Application for a non-material amendment following a grant of planning permission.

Householder application for planning permission for works or extension to a dwelling.
Two single story extensions to side.

Drawing Title
Proposed Elevations

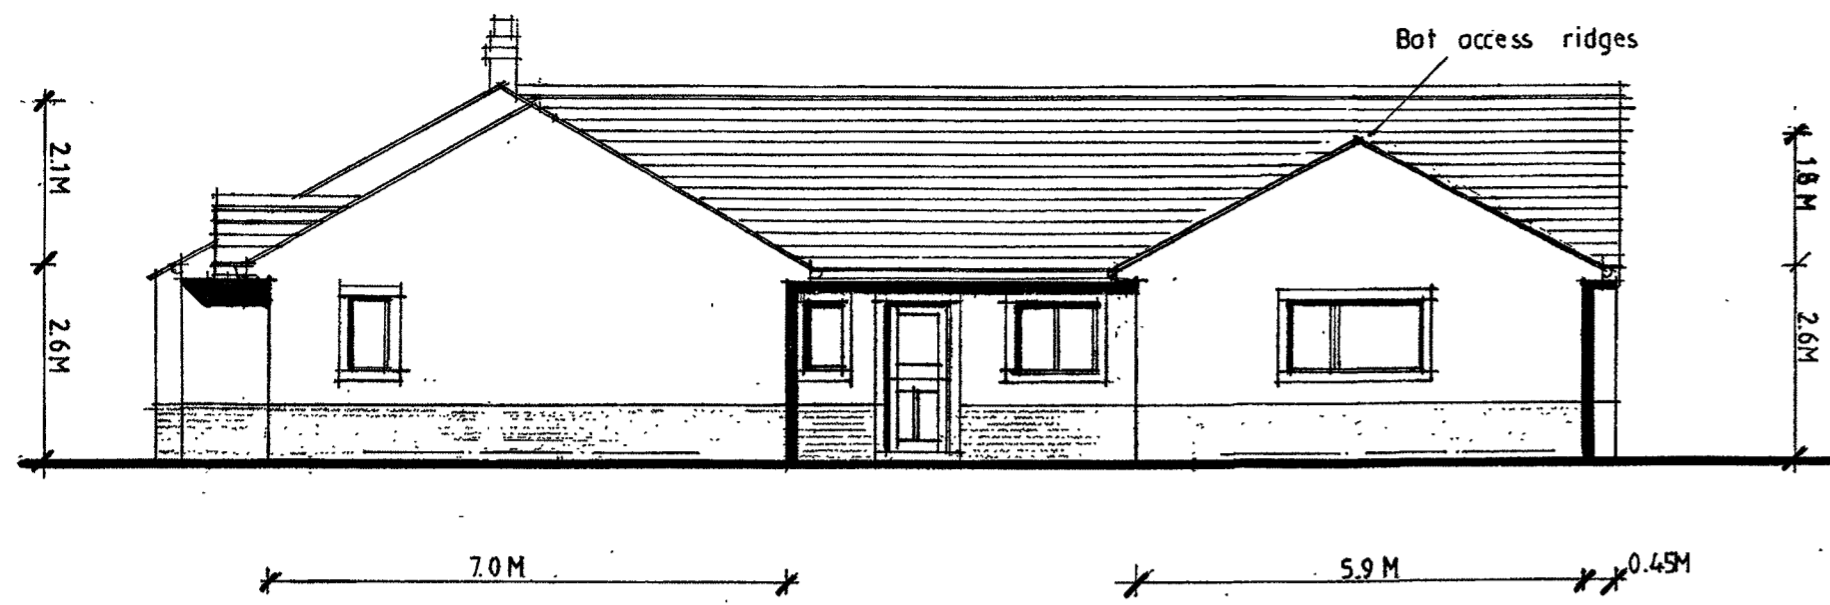
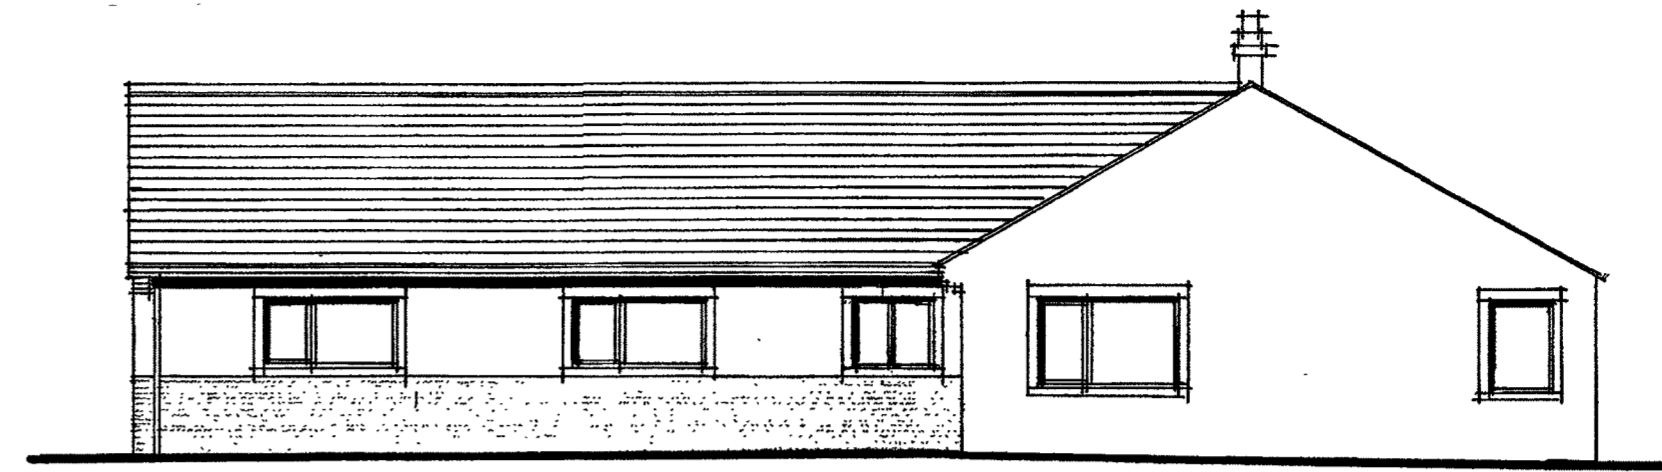
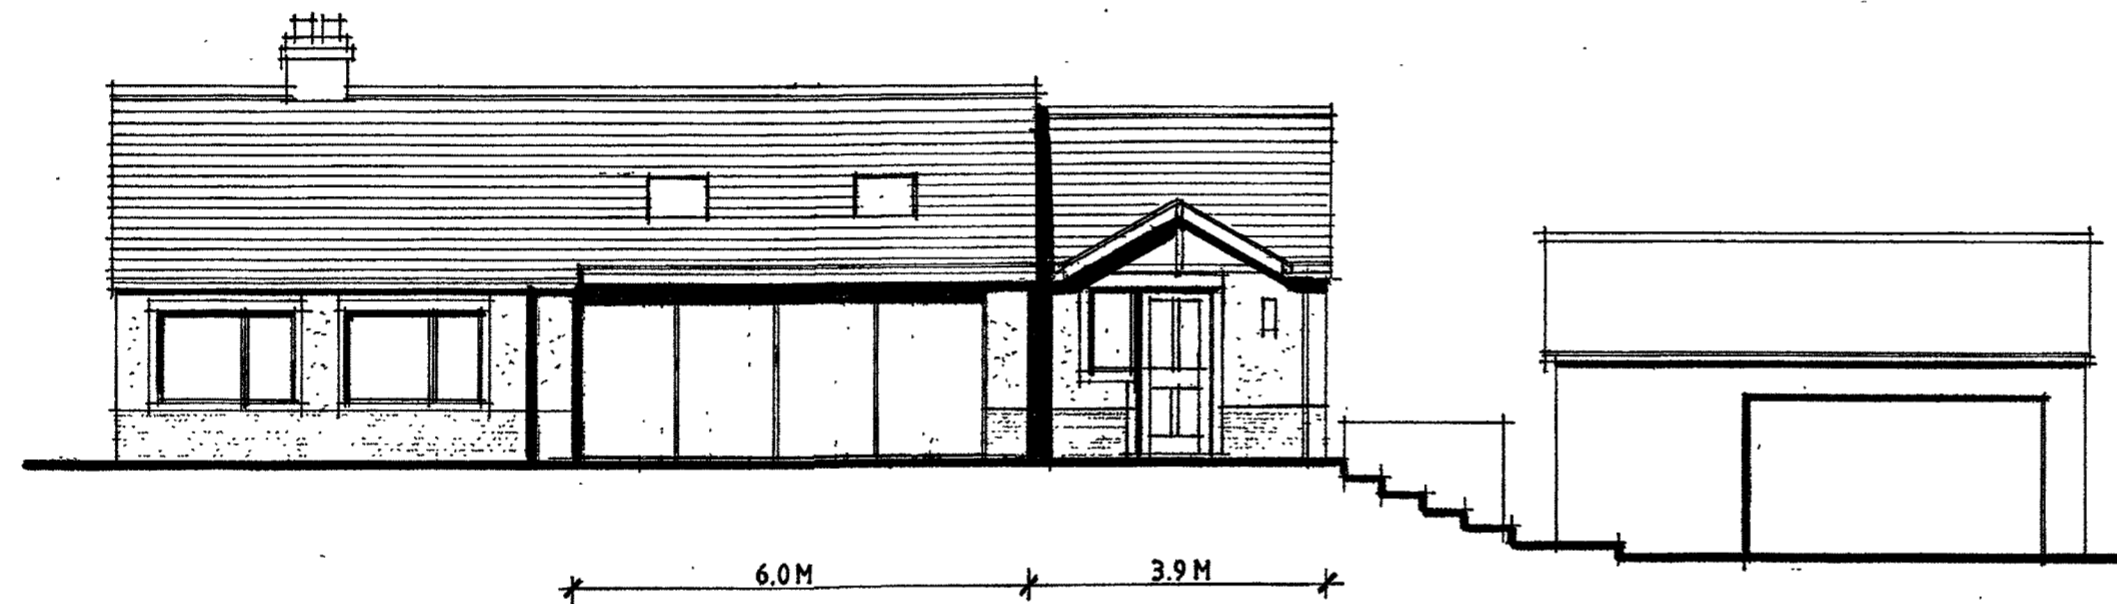
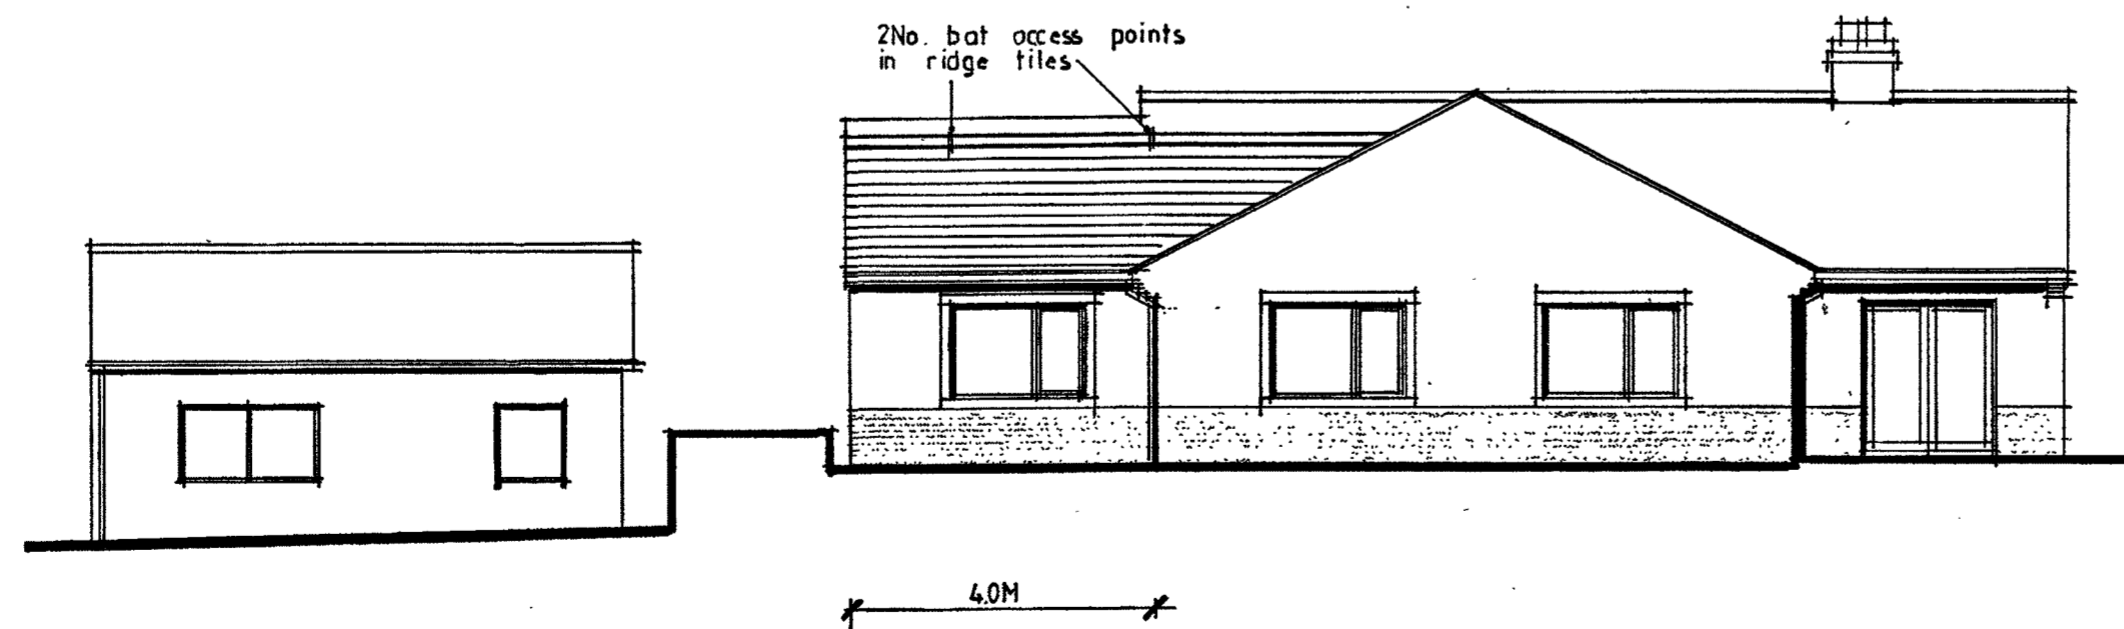
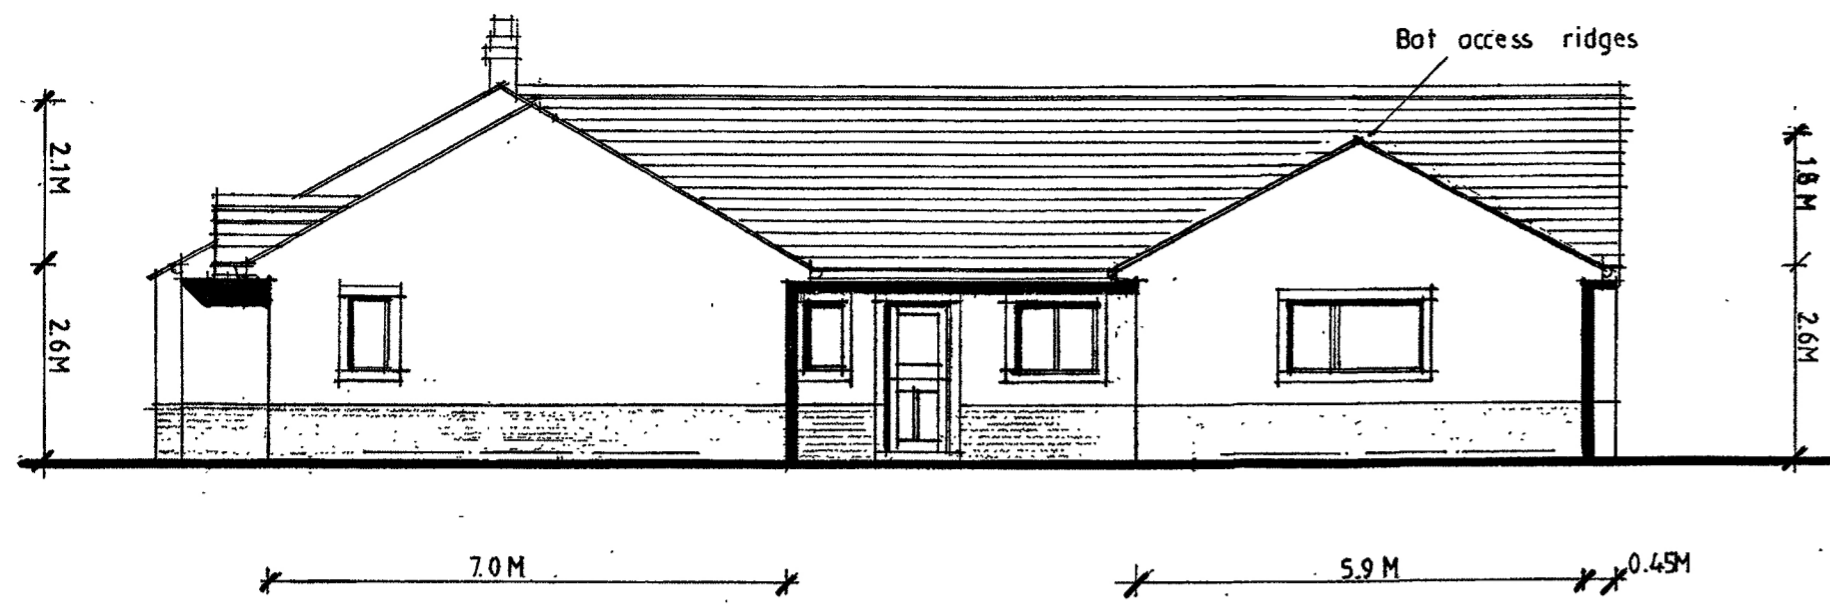
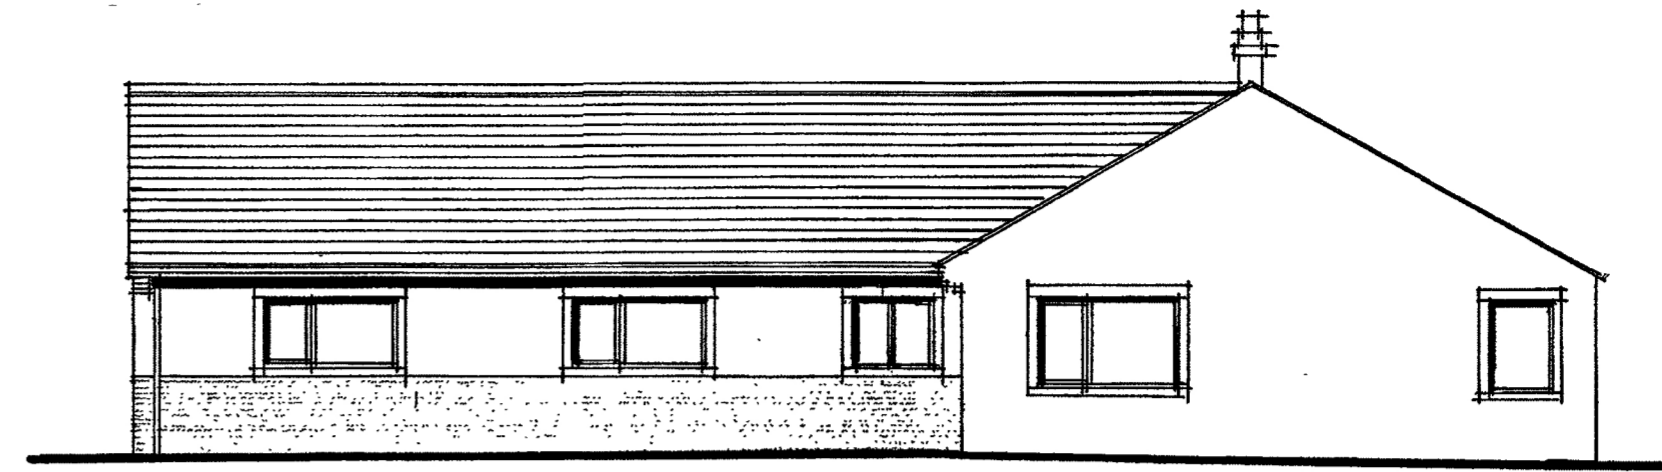
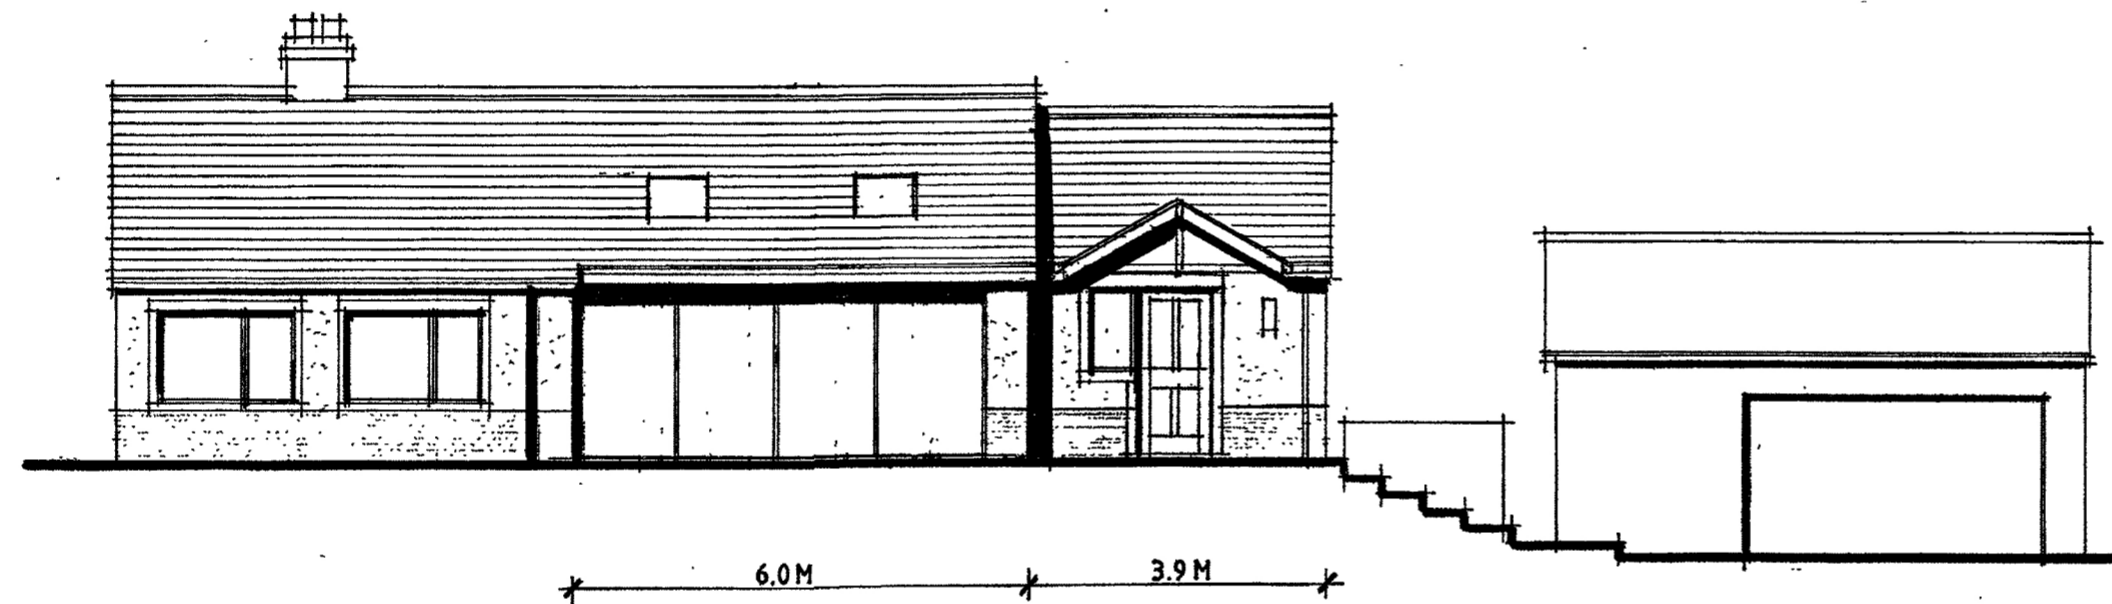
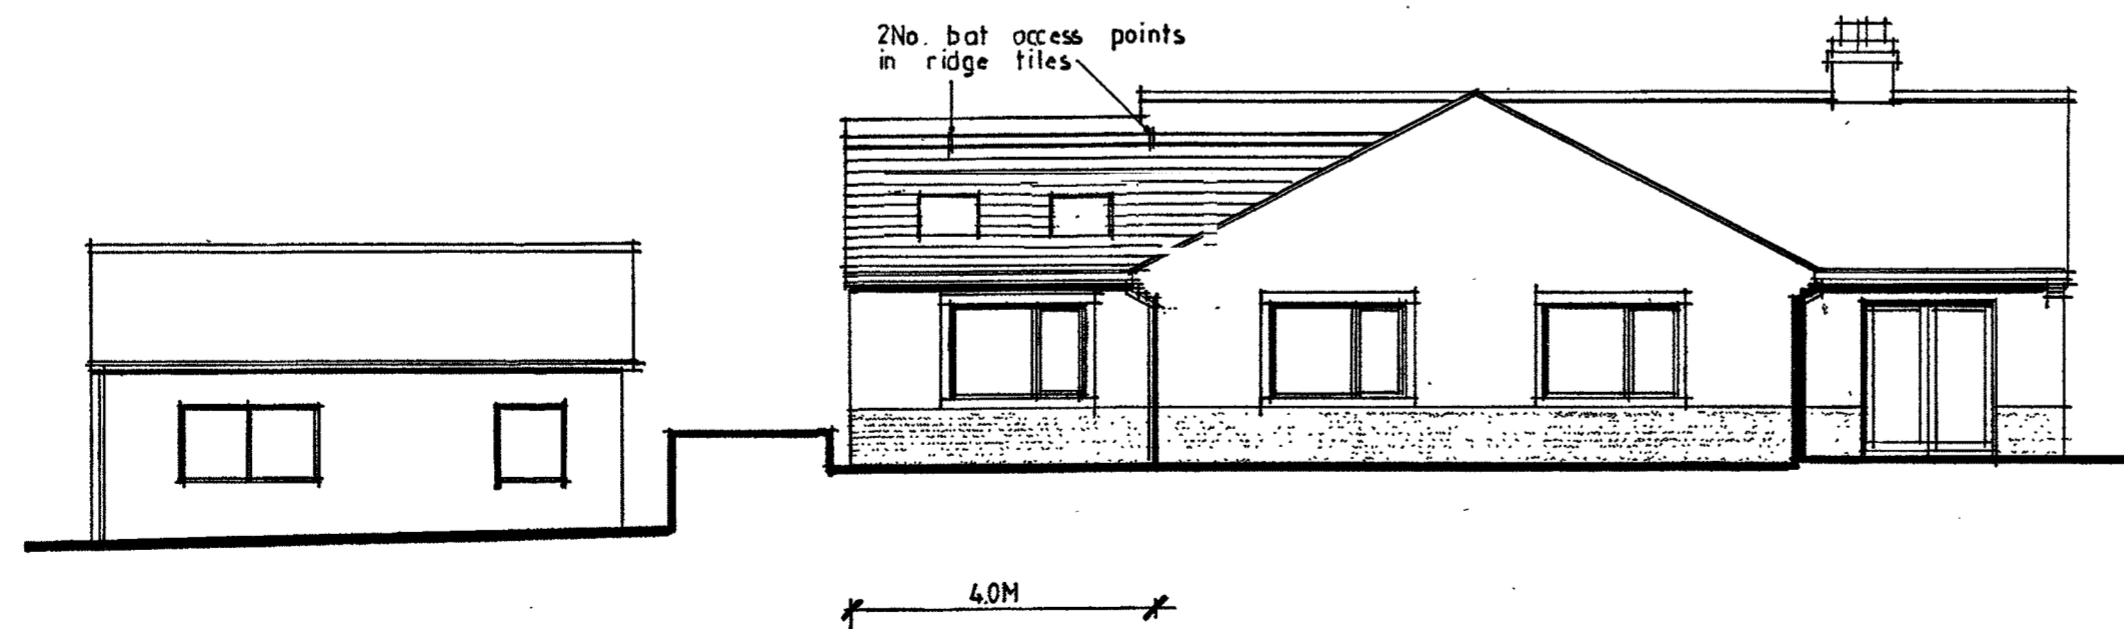
After speaking with the duty planning officer we are removing 1 window (WG23) from bedroom 2 to give more privacy. As we are removing this window we would like to add 2 Velux windows to allow more light in to the room.

Advice given regarding if it was necessary to apply for an amendment to remove a window and add velux windows to an existing approved extension. We were advised that the omission of the window (WG23) would not need any planning consent as it would have a negligible visual impact. However if we wish to install velux roof lights we would need planning consent and to submit an application for a non-material amendment.
